From: Simon Davis
Sent: 22 May 2019 16:34
To: Planning Scanning
Subject: FW: Planning Consultation on FP/42/19/DOC

My comments to conditions 7, 9 and 10 are still outstanding, I have not seen any revised details. Condition 8 can be discharged.

Engineers Comments Regarding Condition 7

NB: Sub-base construction depths are shown as minimum construction requirements. Specific construction depths vary, e.g. where sub-base falls (to collection point) in opposite direction to surface falls. See respective Drainage Layout for specific sub-base levels.

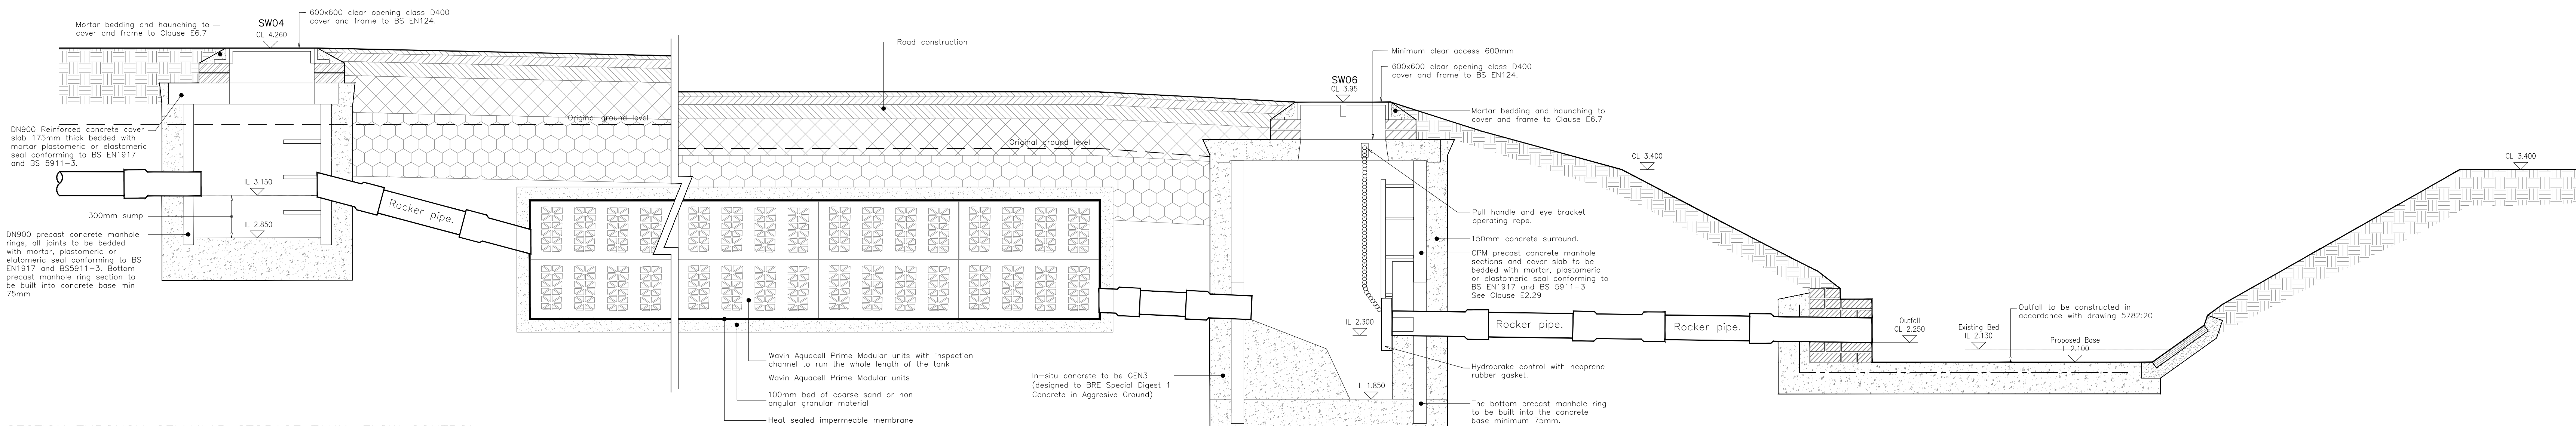
1. Catchpits must be provided upstream of all connections into the attenuation tank.
2. No construction detail drawings have been provided. Please provide construction detail drawings of manholes, catchpits, permeable paving, attenuation tank and hydrobrake.
3. There is conflict between the landscaping proposals and the drainage proposals. Trees must not be located on or near attenuation tanks. Please revise the landscaping proposals.
